TILBURY2

RESPONSE TO INTERESTED PARTIES' DEADLINE 7 SUBMISSIONS

TILBURY 2 DOCUMENT REF: PoTLL/T2/EX/231

Application by Port of Tilbury London Limited for an Order Granting Development Consent for a Proposed Port Terminal at the Former Tilbury Power Station ('Tilbury2')

REVISED SHEET 3 OF THE WORKS
PLANS

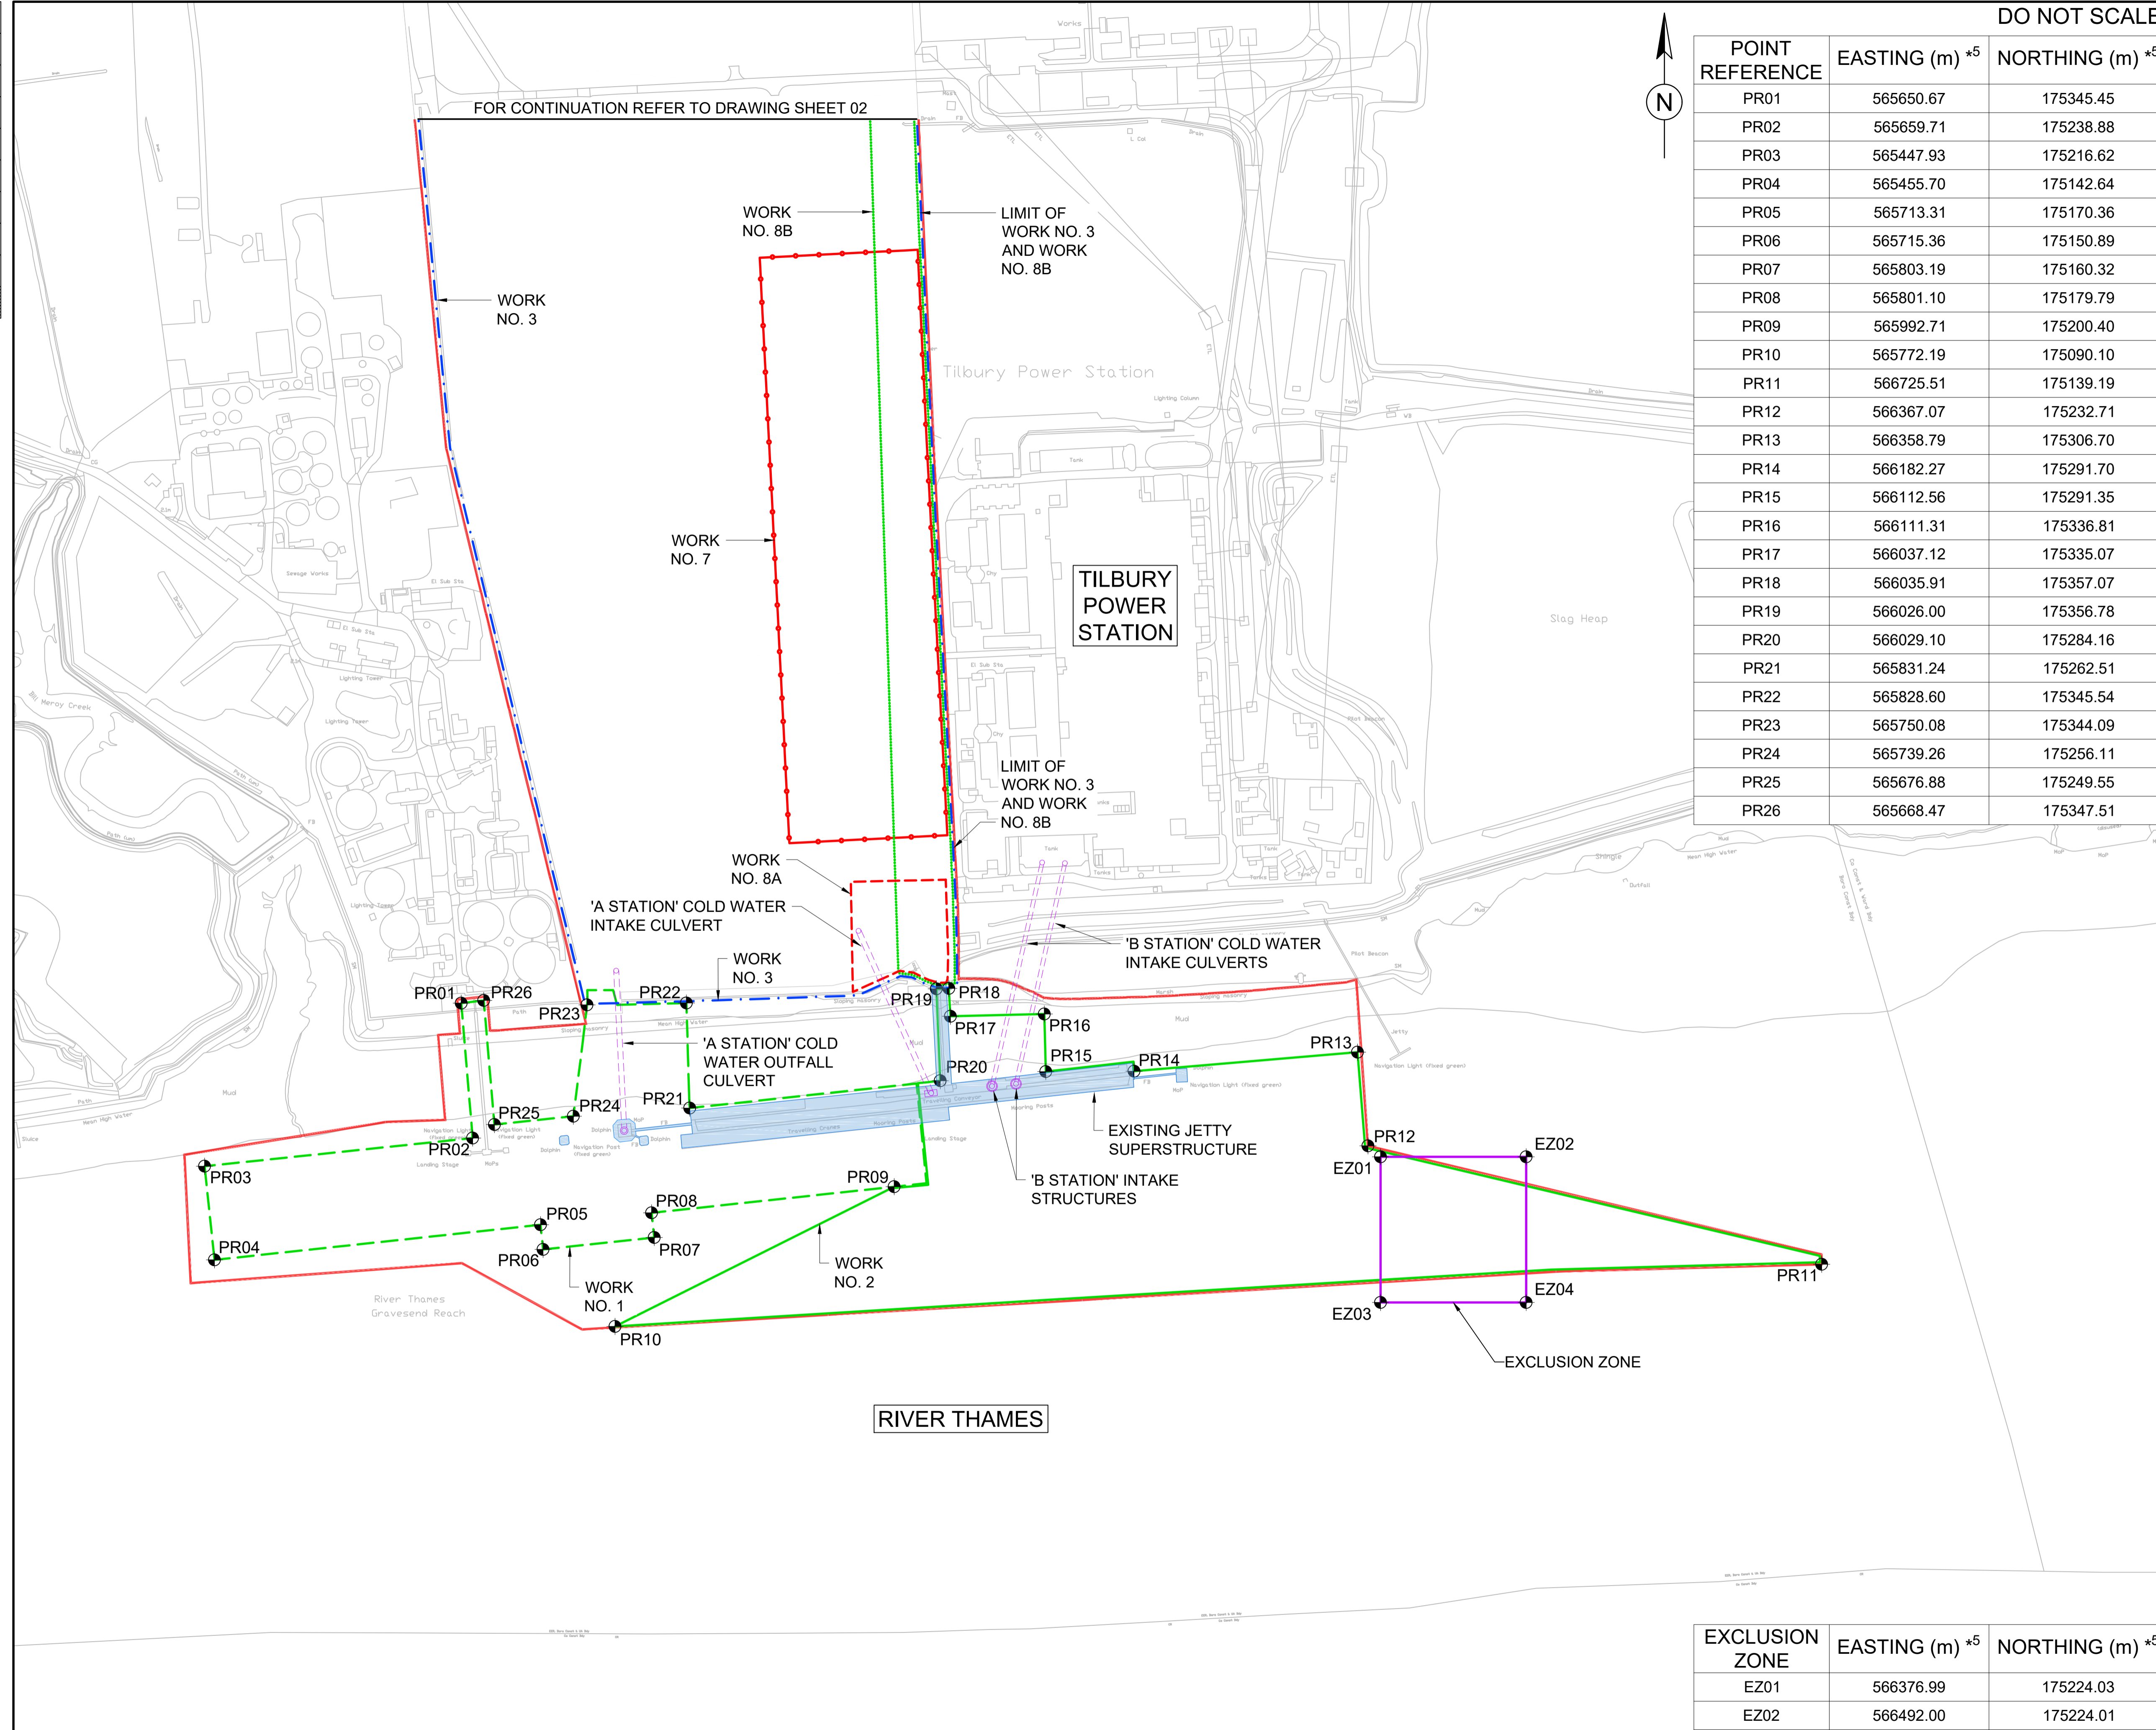
MMO	<p>Response to Rule 17 Request</p> <p>1. Responses to comments on the Panel's draft DCO or schedule of proposed changes</p> <p>1.1.7 The MMO requests that amendments are made to show the entire order limits in the document Work Plans V3 [POTLL/T2/EX/195]. An updated version of this document was not provided as part of the deadline 6 responses.</p>	<p>This is a reference to the extended port limits plan. It is not necessary to show the entire order limits as there is no risk of confusion - the purpose of this plan is to show where the extended port limits are - this is clear from the underlying mapping and would not be rendered more clear by zooming out to show the entire Order limits.</p>
MMO	<p><u>Response to Rule 17 Request</u></p> <p><i>2. Responses to comments on the RIES (paragraphs 2.1 – 2.3)</i></p> <p><i>4. Additional Comments from MMO to Deadline 6 responses (paragraphs 4.1-4.4)</i></p> <p>2.1. With regard to paragraph number 4.12 – The MMO refers to section 1.1.4 above regarding the installation of groynes requiring a separate marine licence. The MMO welcomes the Applicant intent to amend the DML as described. Due to the references in the REIS, the MMO still wish to highlight that as part of the HRA process if an AEOL cannot be ruled out then alternative solutions must be considered, and then if there are no alternative solutions then the next stage of the derogations must be considered, compensation (Article 6(4) of the Habitats Directive and regulation 64 of The Conservation of Habitats and Species Regulations 2017 and regulation 29 of the Conservation of Offshore Marine Habitats and Species Regulations 2017 respectively). The creation of new saltmarsh habitat is compensation not mitigation. Compensation is undertaken to maintain the coherence of the Natura 2000 network. The implementation of mitigation means that an AEOL can be ruled out. As compensatory measures are required the applicant cannot conclude no that the activities will have no AEOL. The Applicant may wish to contact Natural England to discuss this aspect further...</p>	<p>The Applicant notes that the MMO comments on the proposals to install groynes in a section of the Thames shoreline within the Order Limits to create conditions favourable to saltmarsh accretion. The MMO notes that this is a compensation measure for habitat losses. The MMO indicates that this is therefore a matter that engages with the consideration of AEOL as part of the HRA process, and in line with European case law.</p> <p>This misunderstands and conflates two different issues and therefore is misconceived for the following reason, and as previously set out in the Applicant's submissions.</p> <p>The creation of compensatory saltmarsh habitat along the Thames shoreline is not intended as compensation for any significant effect or adverse effect on integrity as regards any European or Ramsar Sites. The compensation is to ensure no net loss of 'priority' saltmarsh habitat in accordance with the duties levied by domestic legislation – specifically sections 40-41 of the Natural Environment and Rural Communities Act (NERC Act) 2006 - and to assist with the project target of avoiding net loss to biodiversity more generally in accordance with applicable planning policy. If the saltmarsh creation were not proposed at all, there would not be a significant effect on the SPA and Ramsar Site, nor an adverse effect on integrity. The HRA report [REP7-018/020] is explicit in stating that the compensatory saltmarsh creation is not relied upon in reaching its no AEOL conclusions (see Appendix 11 integrity matrices footnote b).</p>
